**RFI #: 210**  
**Date:** 11/26/2012  
**Job:** EB-02 Keller Springs Lofts  
**Phone:** 877-777-5115

**Subject:** Brick heights at MC3 & MC4

**Drawing:** 2/4.3, 3.1B  
**Cost Impact:** None

2 DIVISION 'B' WEST ELEVATION NFI 210

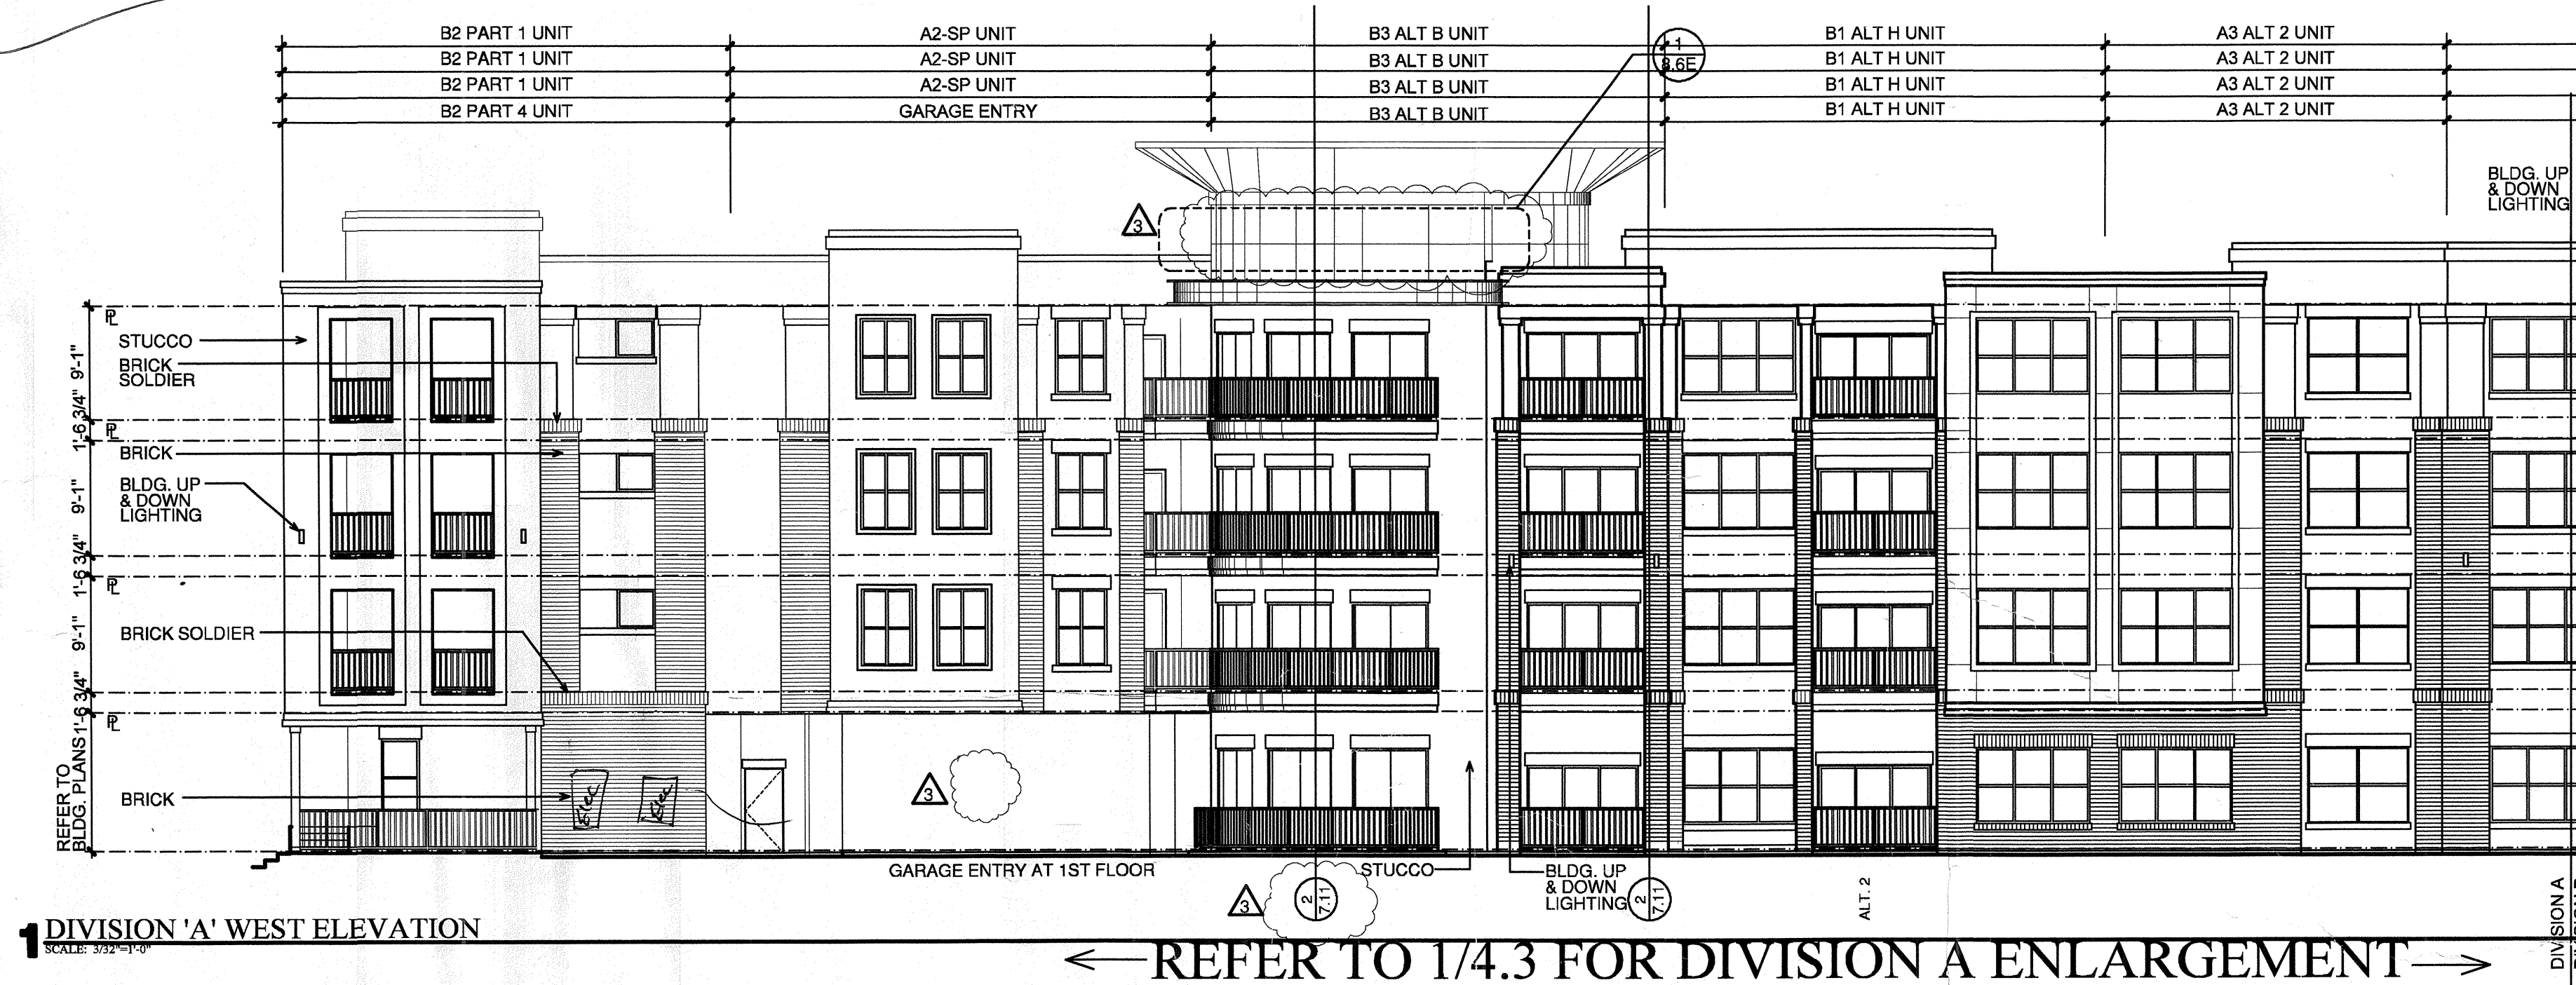
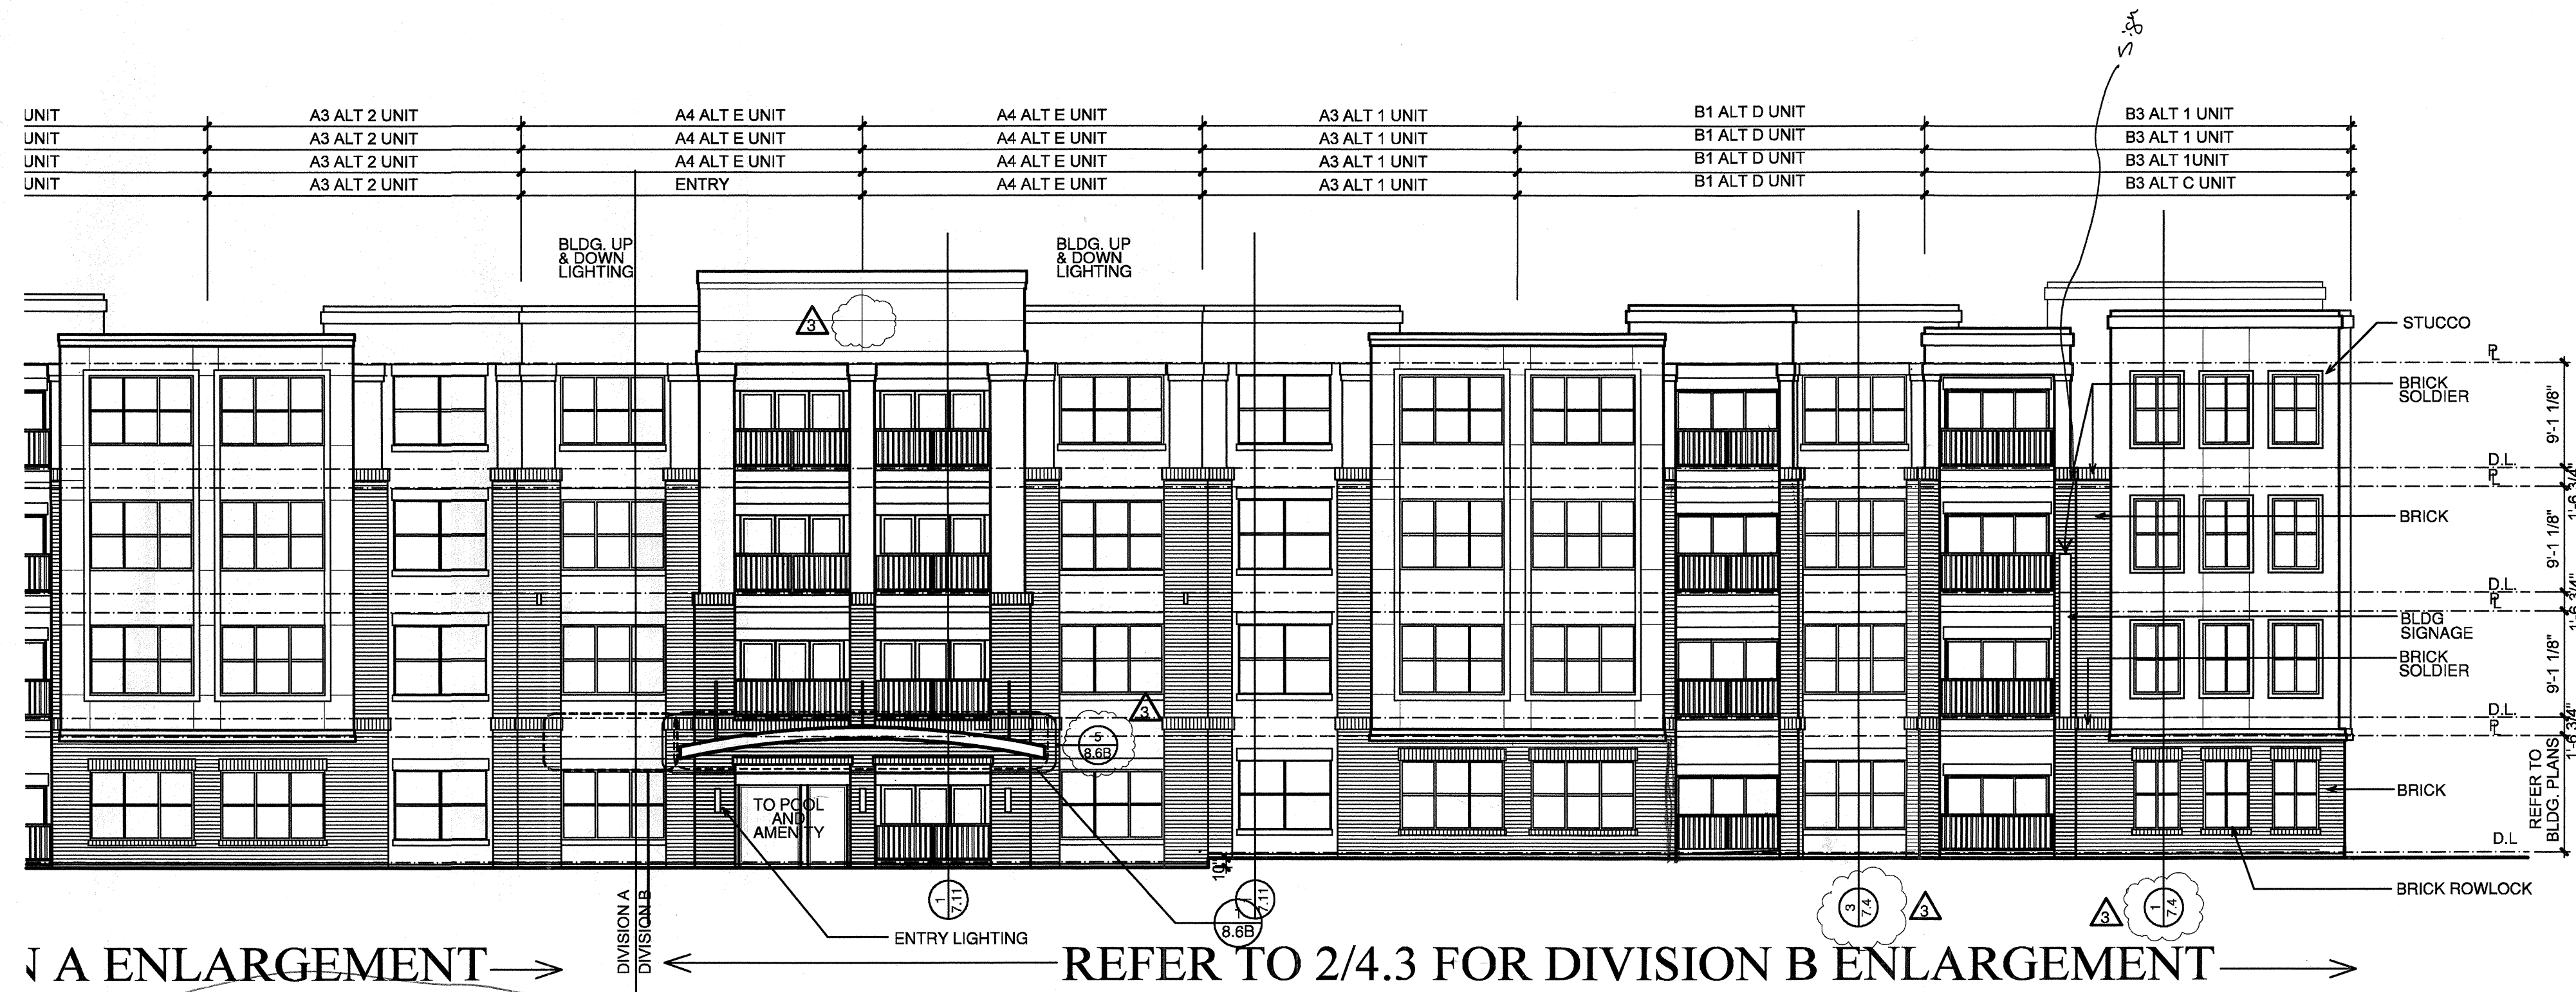
**Request:**  
See attachments of 2/4.3 and 3.1B for questions concerning the area at MC3 and MC4 and the height of the brick. There are no building elevations showing this area as to where the brick stops and the stucco begins. Please advise

**Response:**  
Please bring the brick up to a soldier course matching the walls beside it on the elevation. Drawings 3.2B and 3.3B show a brick hatch in this area in question. Consult structural drawings for proper lintel size.
